From: stephen jupp [REDACTED]
Sent: 07 July 2015 13:59
To: Anita Gardner
Subject: Re: FG/85/15/PL - Workshop/store - Onslow Caravan Park, Ferring
Importance: High

I note the approved siting and dimensions of the proposed workshop under planning permission FG/161/14/PL.

| Project | ADC/5/14   | Sheet | 4F |

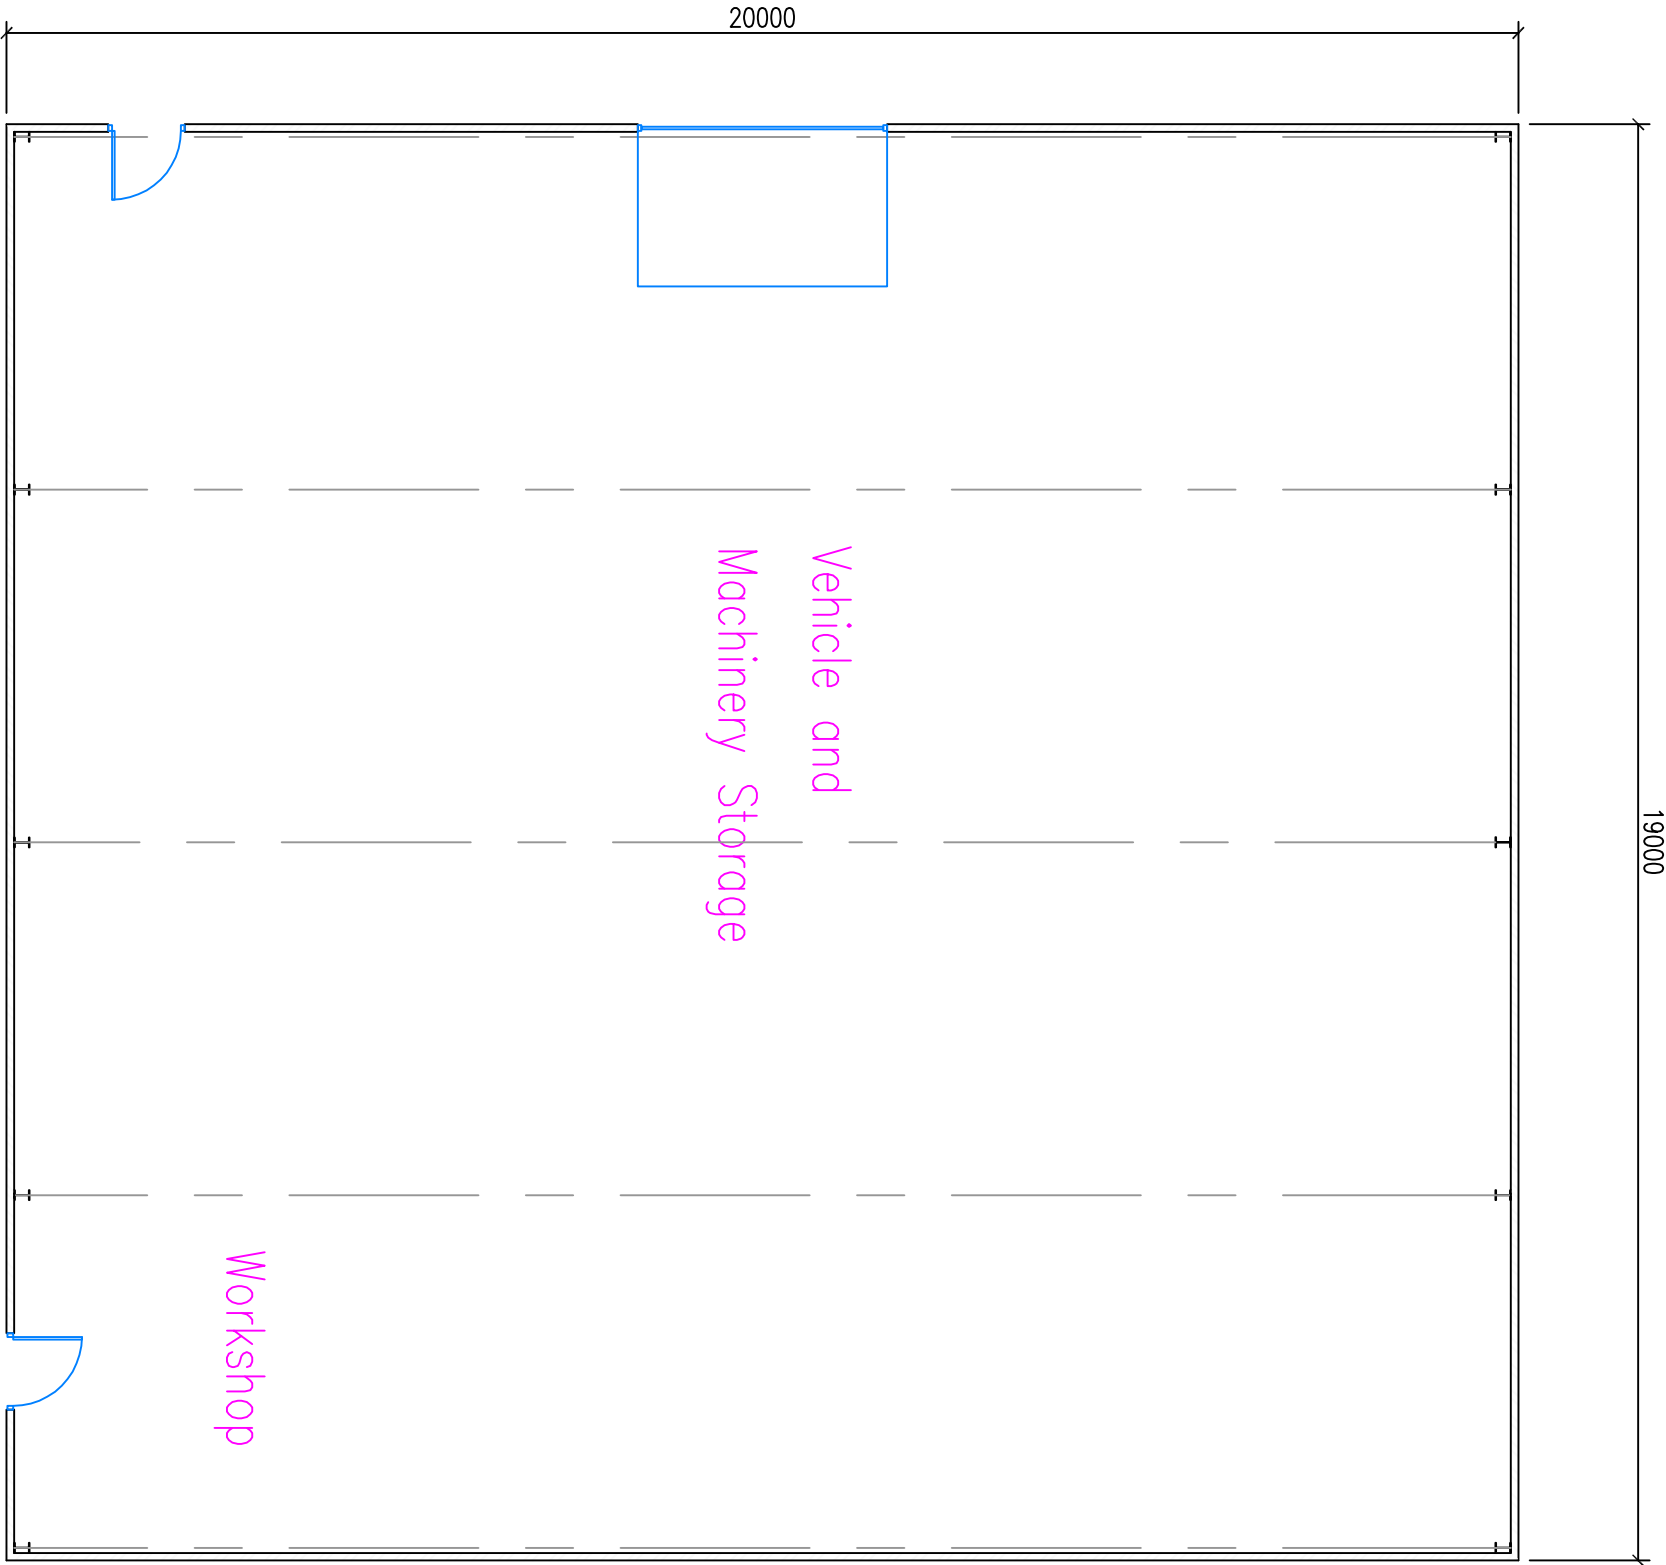
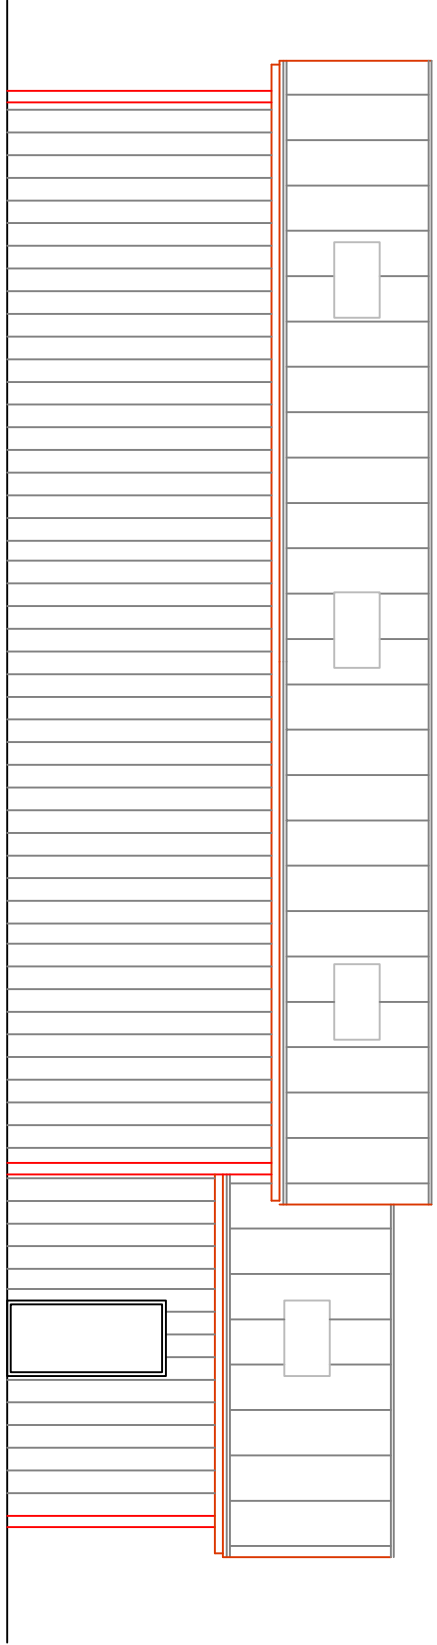
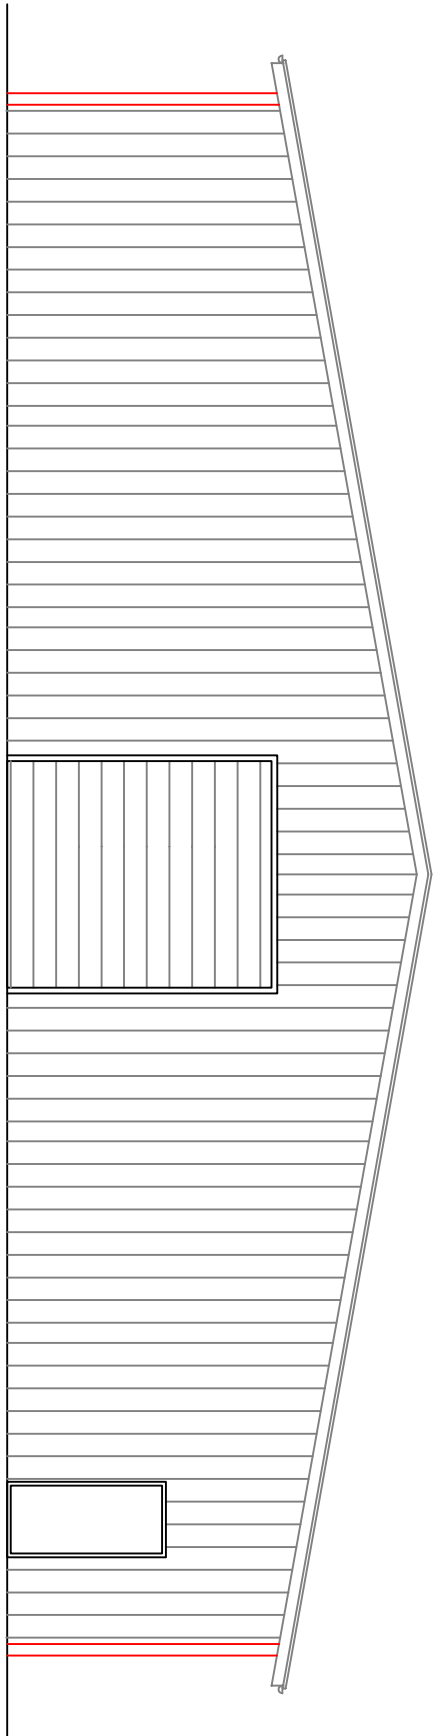
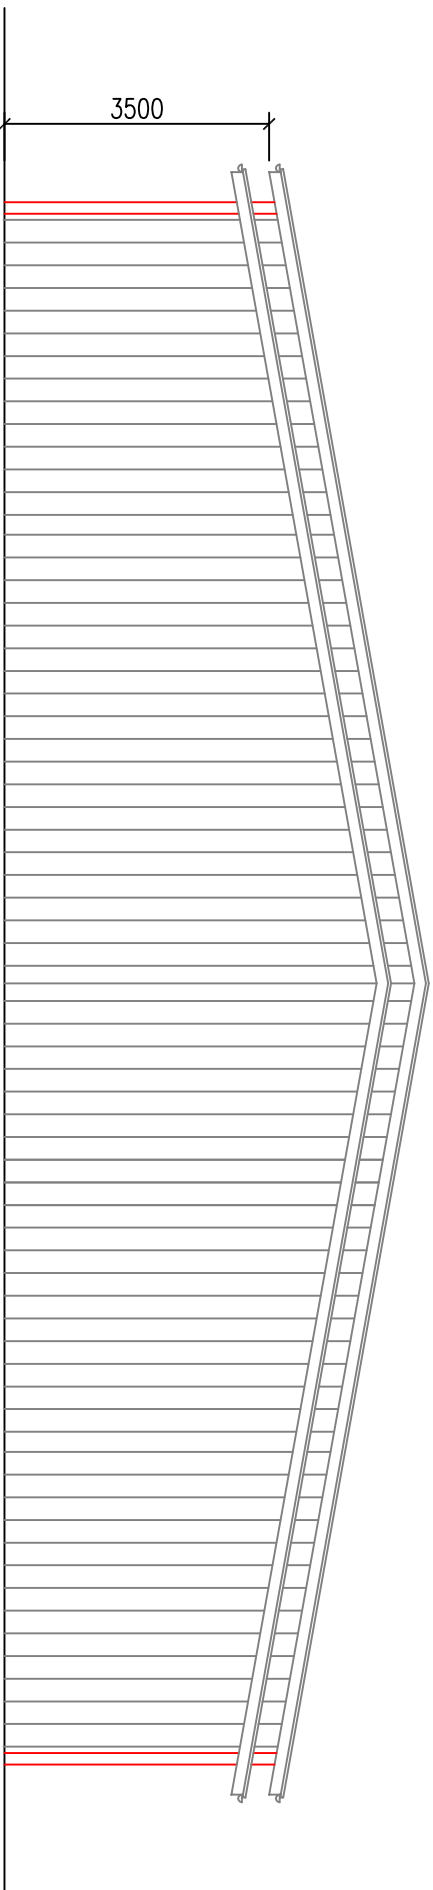
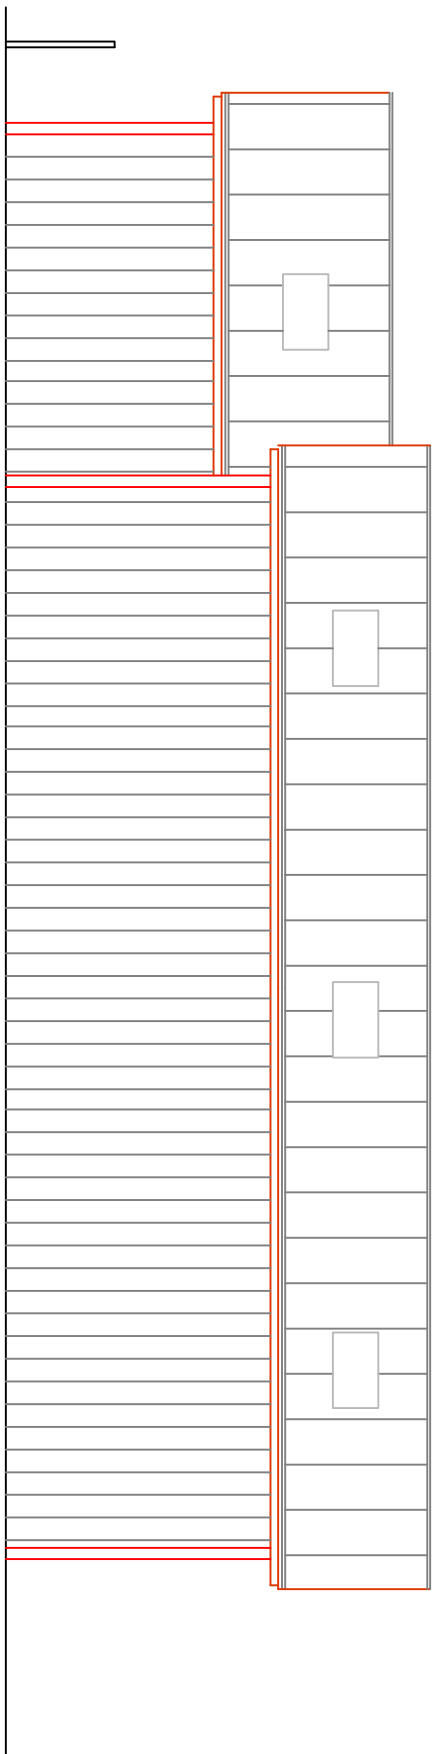
Steve,
Is it not possible to reduce the width by 1 metre and not increase the length?
Anita

Since this proposal has a more central position and is closer to the site frontage it would be more prominent in terms of visual amenity. I would therefore appreciate consideration being given to a reduced footprint . Whilst the refused application FG/49/15 had a greater height it did have a smaller footprint and there may therefore be a possibility of the overall floor area being reduced without a need to increase the height of the building whilst still achieving the necessary storage. Without prejudice, I would appreciate revised plans within 10 days of the date of this e-mail.

Anita
i have reduced the width by 1.5m
steve

in this regard i could reduce the width and increase the length, so that when you enter the site much less of the building will be obvious. it is also possible that ridge will be slightly lower as a result in the reduction in width
